Our ref: NO/2012/103817/02-L01
Your ref: 3/2012/0166
Date: 20 June 2012

**PROPOSED CONSTRUCTION OF EARTH BANK SLURRY STORE
SMALLEY FOLD FARM, COMMONS LANE, BALDERSTONE, LANCASHIRE**

Proposed earth banked slurry lagoon at Smalley Fold Farm, Commons Lane, Balderstone, BB2 7LP~

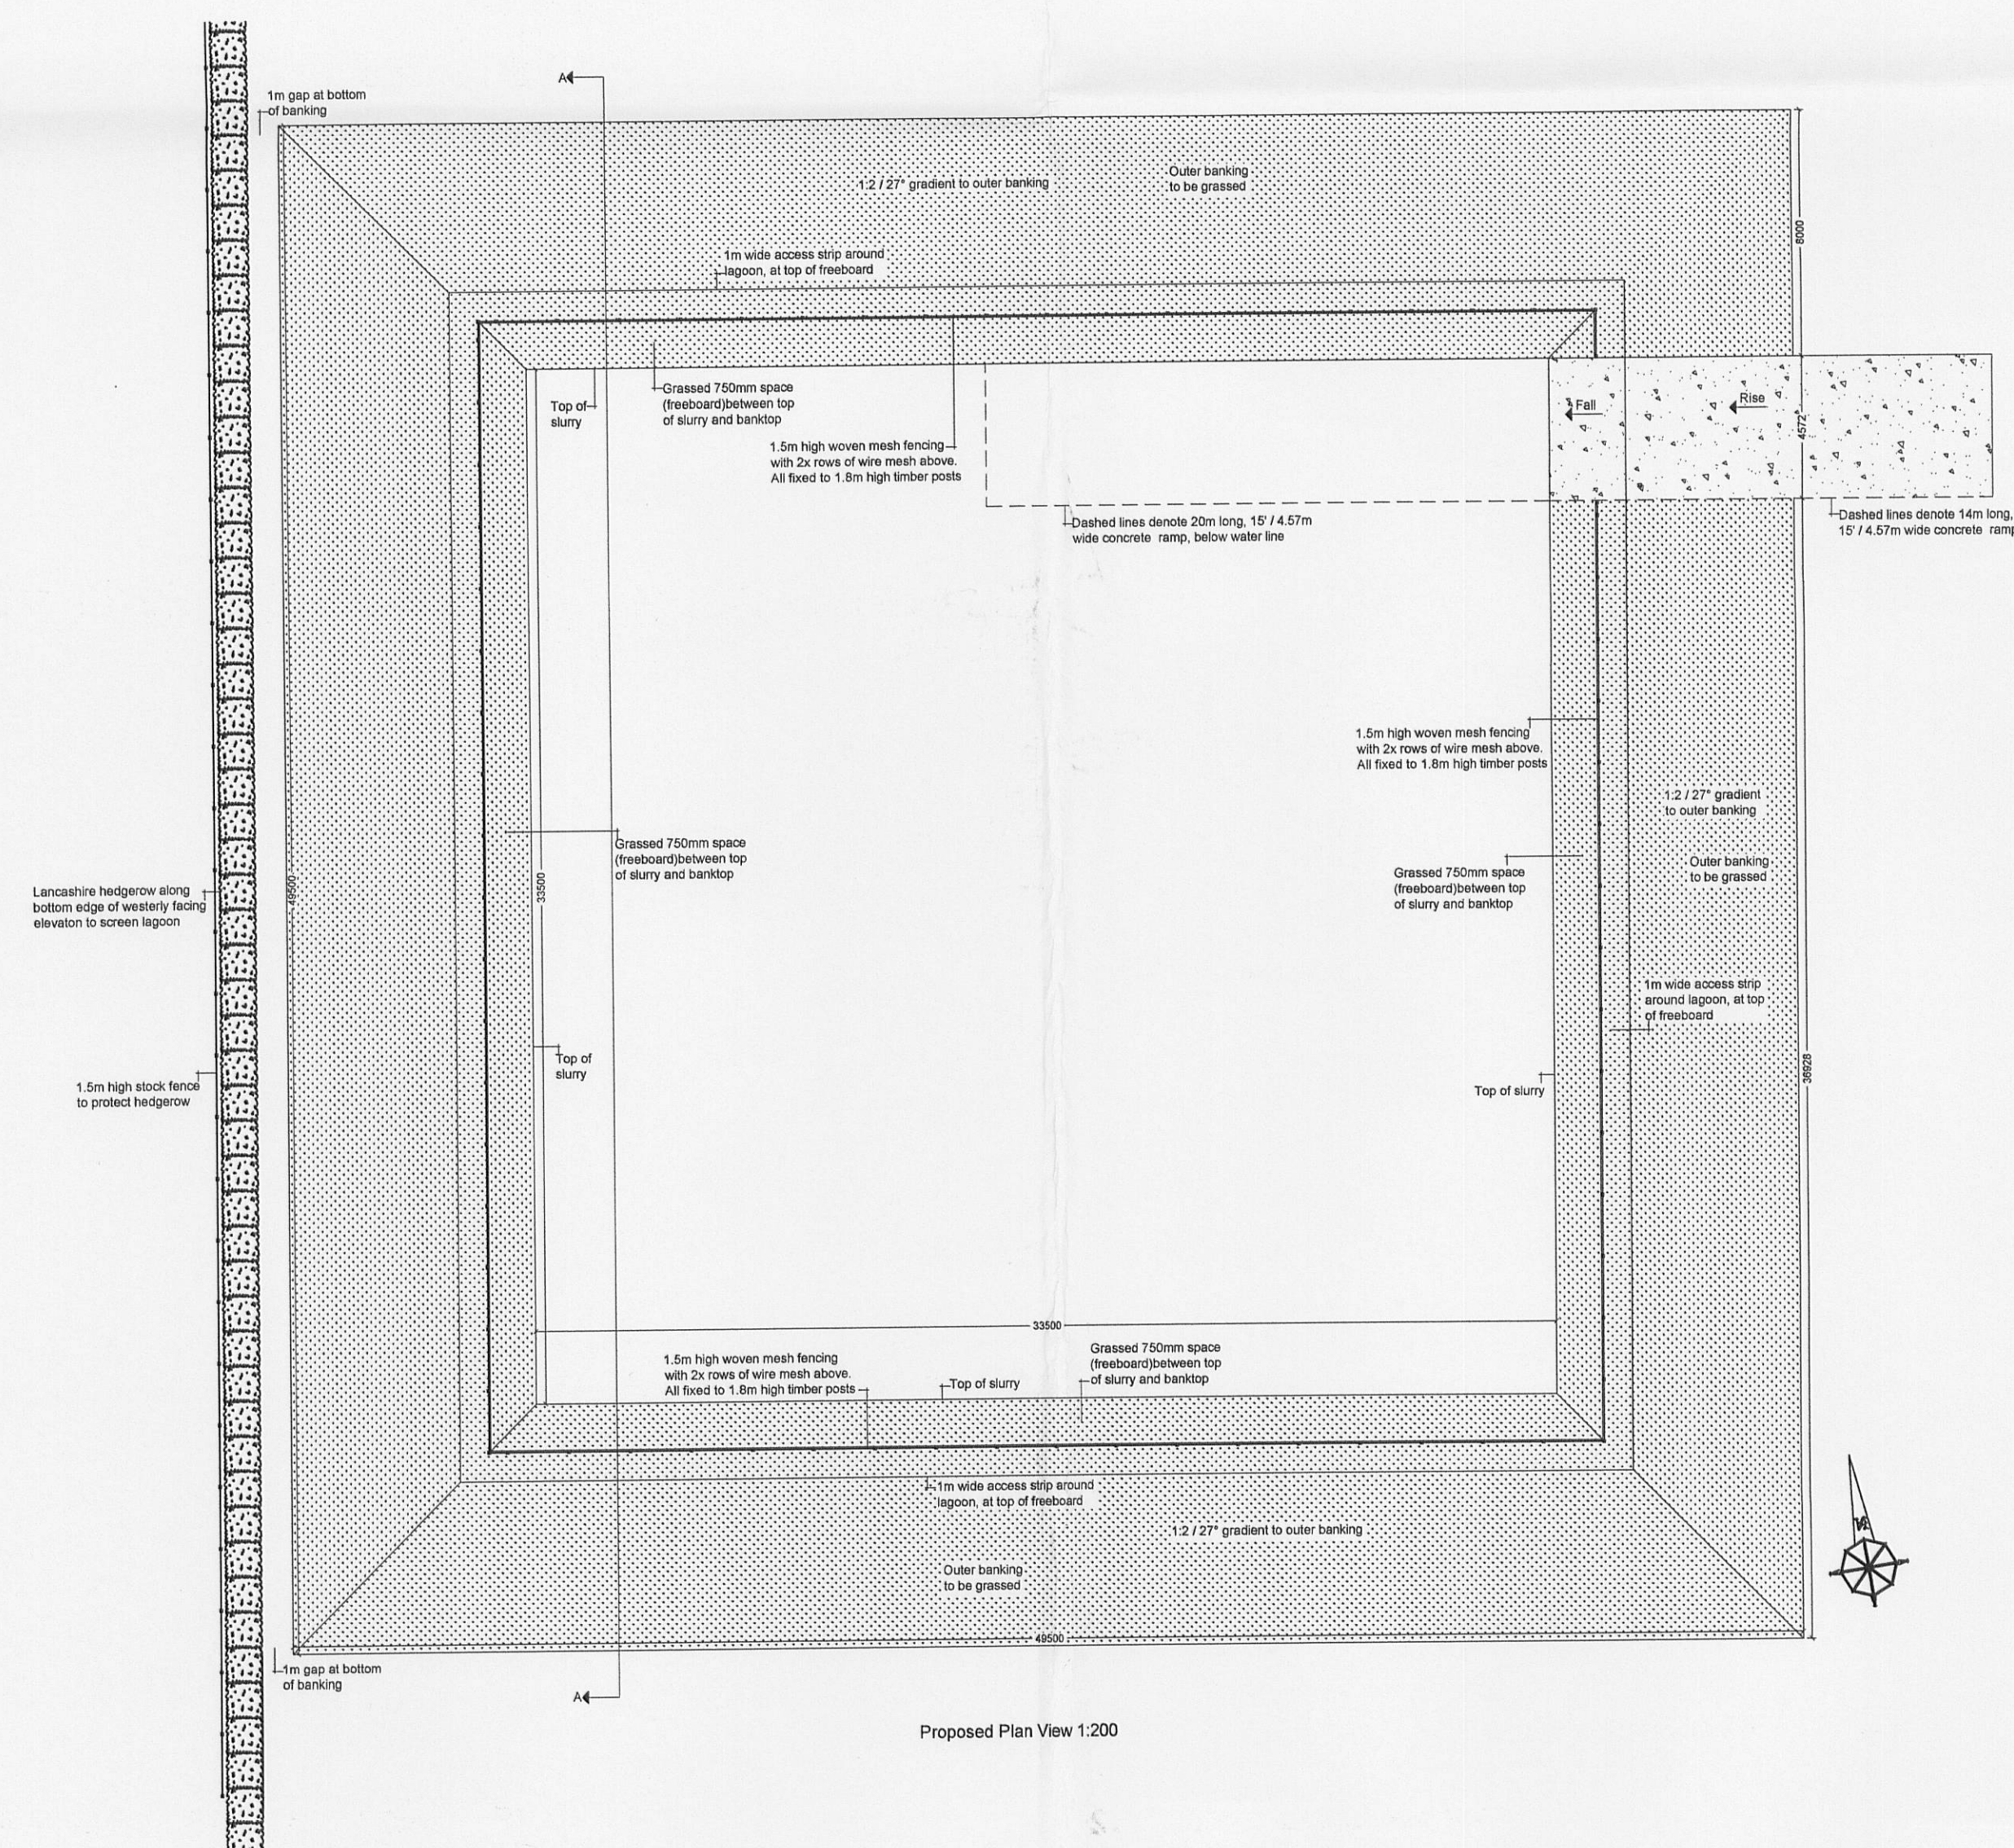
We have subsequently discussed the proposals with the applicant's agent. The permeability tests will determine whether or not the ground conditions are appropriate in the location of the proposed slurry lagoon. However, in a worst case scenario, if the ground conditions were not suitable this could be resolved through the importation of appropriate material or the provision of an impermeable liner within the lagoon. While this is more costly, we understand that the applicant is prepared to do this if necessary to enable the slurry store to be constructed in the proposed location.

The slurry store (in conjunction with any other slurry storage on the farm) should accommodate the maximum quantity of slurry likely to be produced and directed to this system in any continuous four-month period. The calculations submitted as part

of the application state that the proposed lagoon will afford eight months storage capacity, which would clearly satisfy the regulations.

CONDITION Prior to the commencement of development, permeability testing of the ground within the footprint of the proposed lagoon shall be undertaken and the results submitted to the council. Where the in situ soils are not shown to be suitable for the proposed development, full details of a scheme for lining the lagoon with an impermeable barrier shall be submitted to and approved in writing by the local planning authority. The development shall proceed in accordance with the approved scheme
